Date: 12 March 2024

Application by Gatwick Airport Limited for an Order Granting Development Consent for the Gatwick Airport Northern Runway Project

Tunbridge Wells Borough Written Representation (unique reference number 20041435)

Title:
Ordnance Survey Base Map Identifying Category 3 and Noise Insulation Scheme Boundary - Sheet 1 of 4

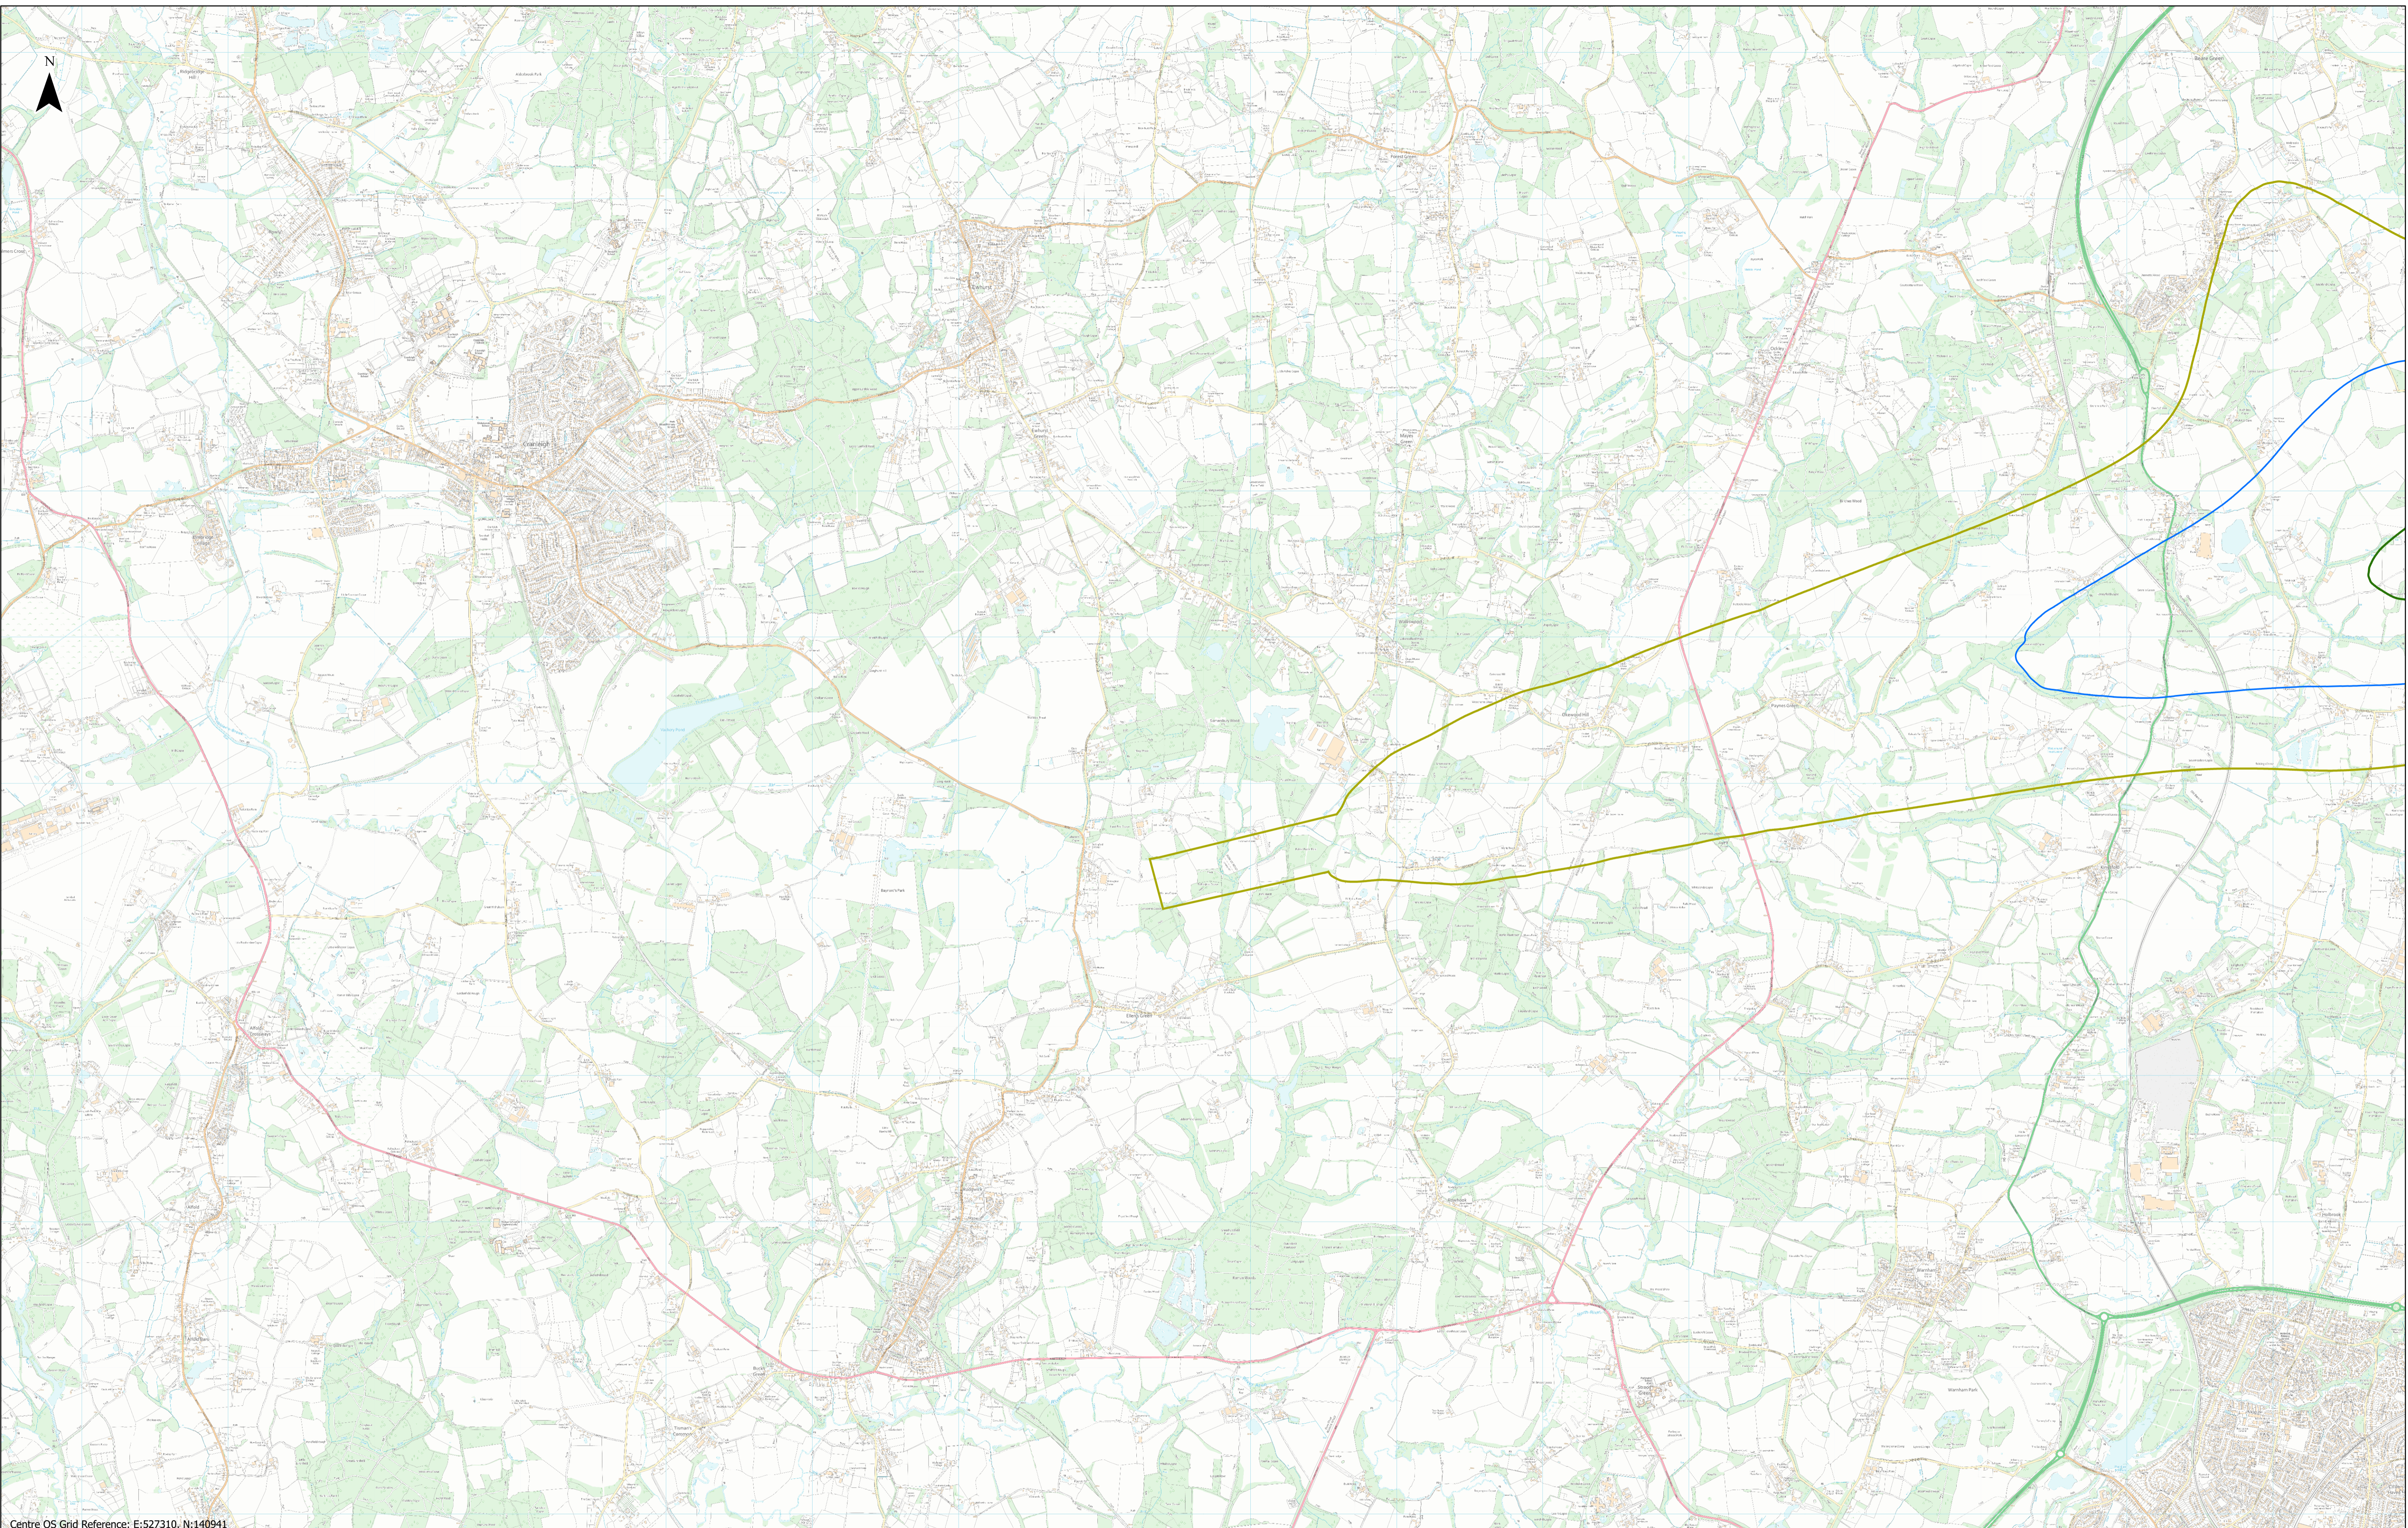
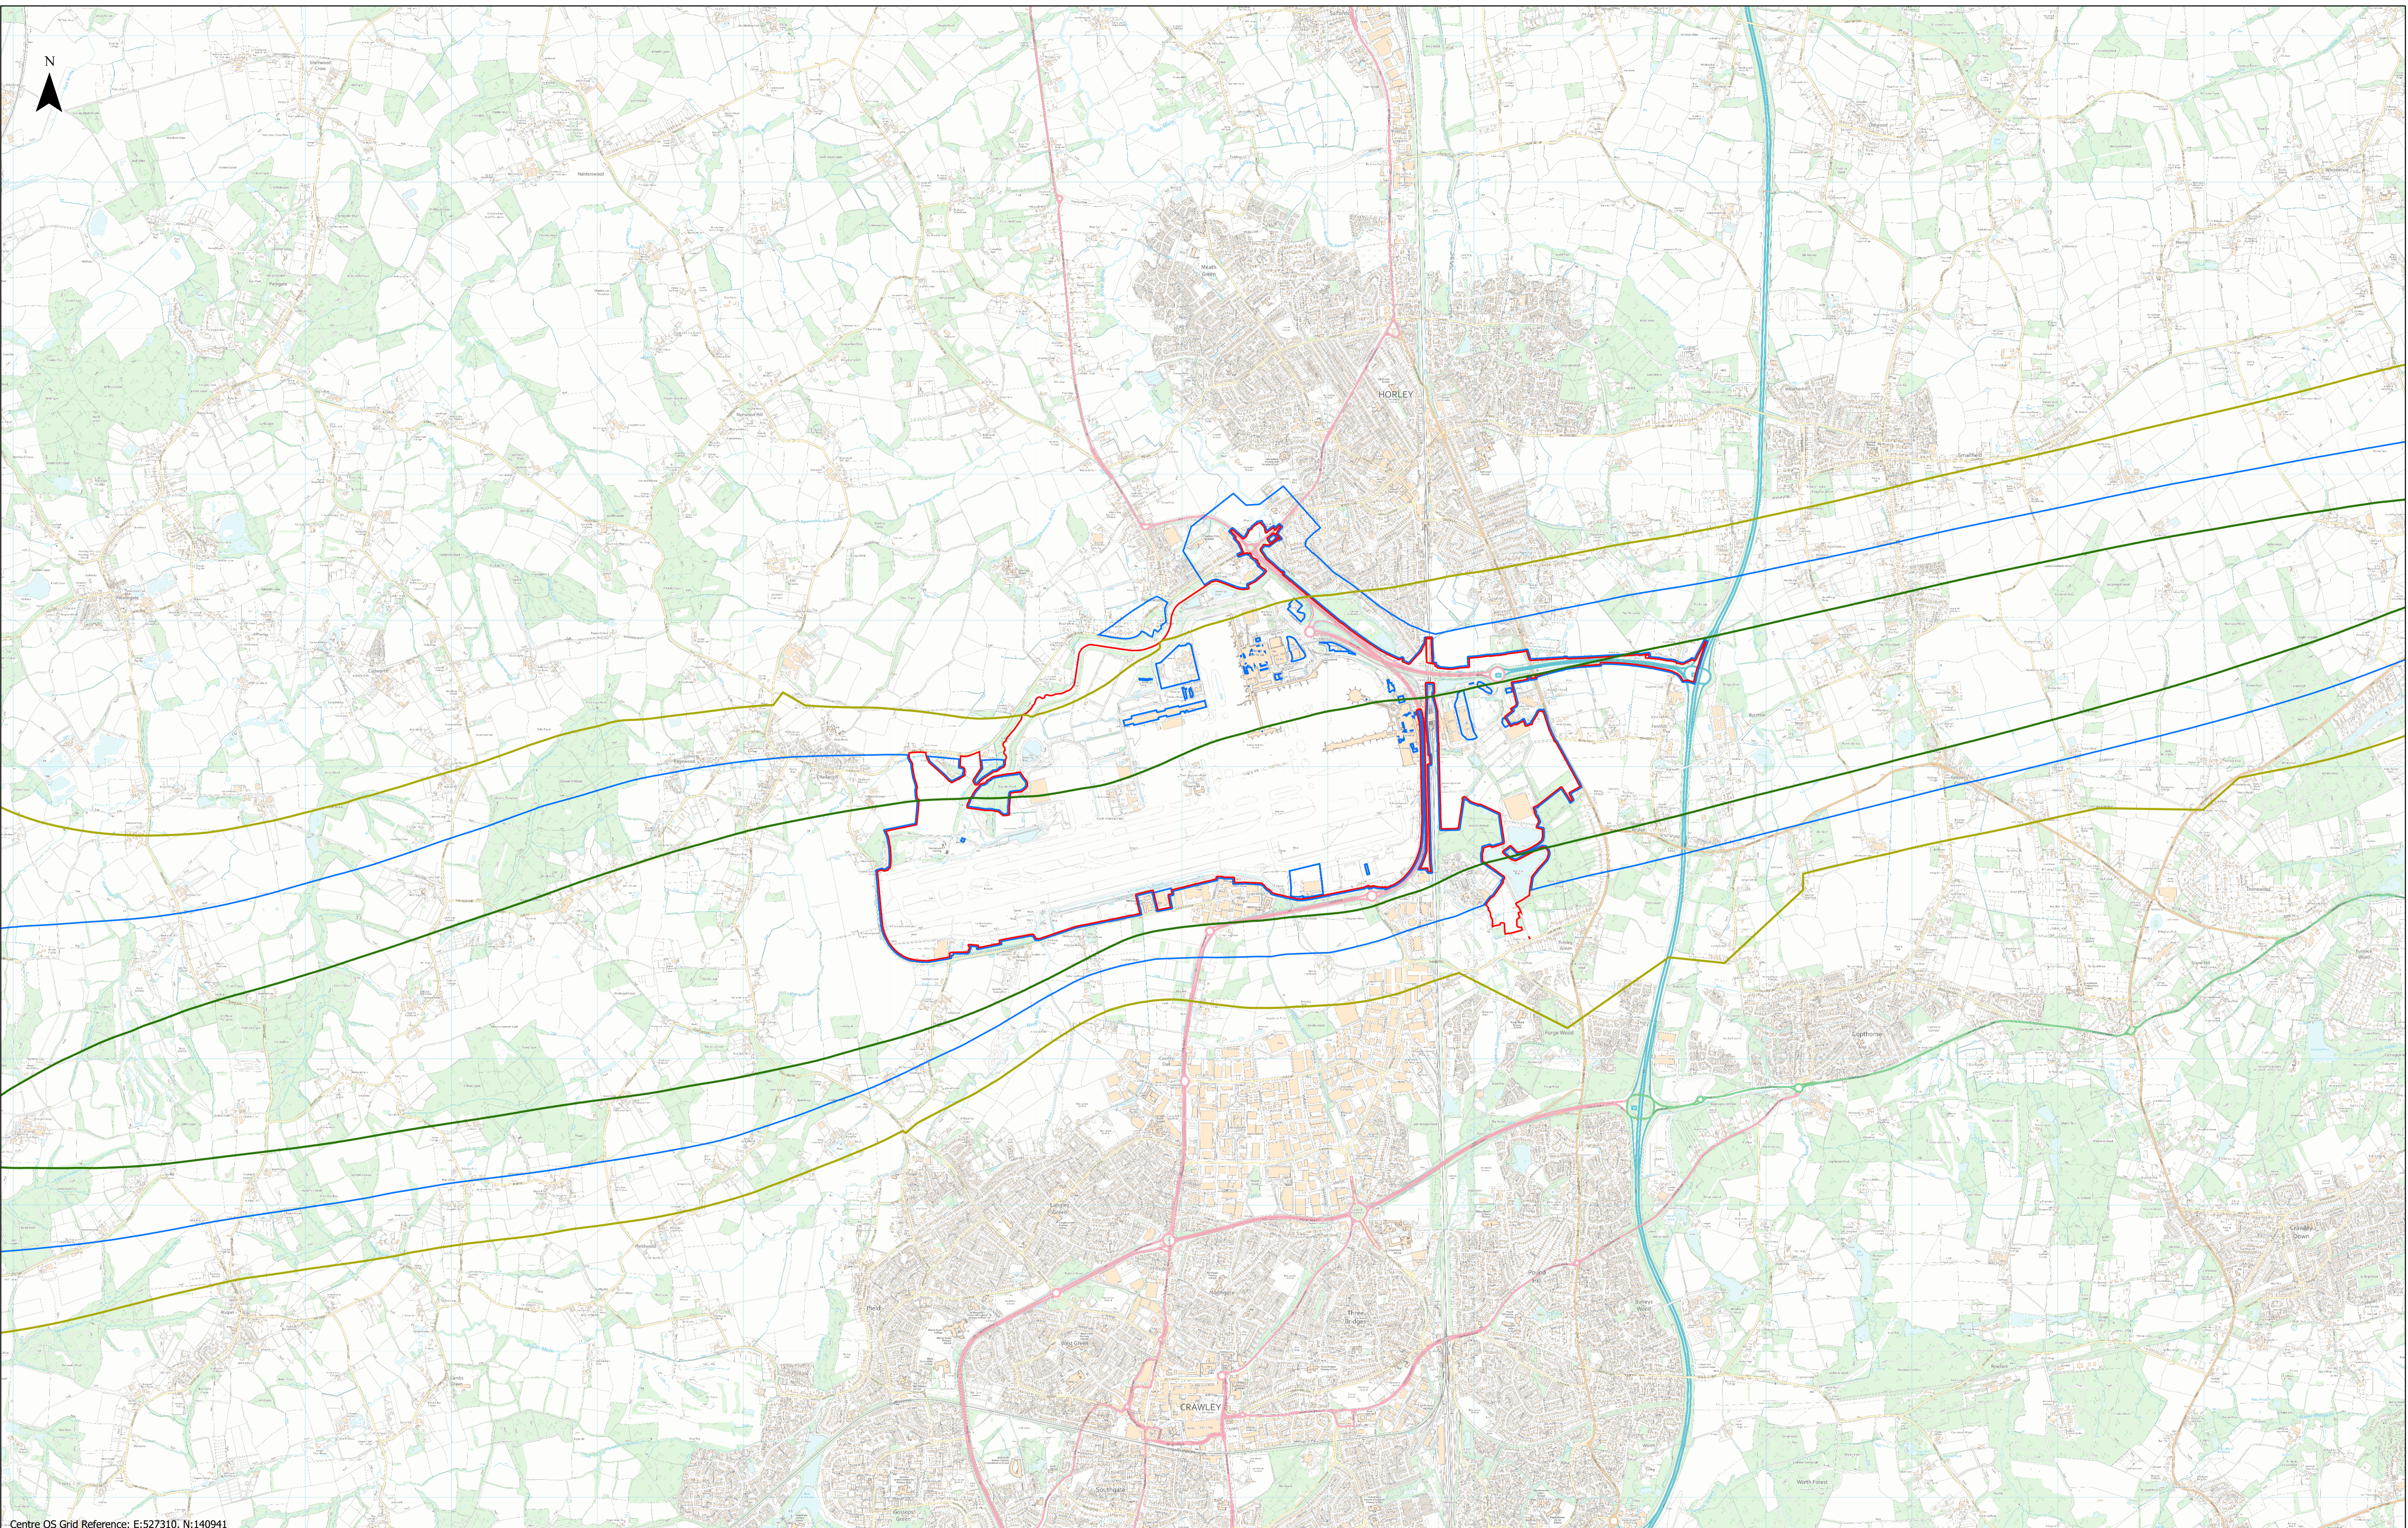
Currently the Applicant's Noise Insulation Scheme [APP-180] document provides a small-scale map of the proposed boundaries. Given Kent's distance from the airport, it is likely any eligible households will be located within the Outer Zone but it is difficult to determine from the size of the map exactly where the boundary will fall. In addition, information should be provided around which schools would be included within the Schools Insulation Scheme, along with details of other noise sensitive receptors.
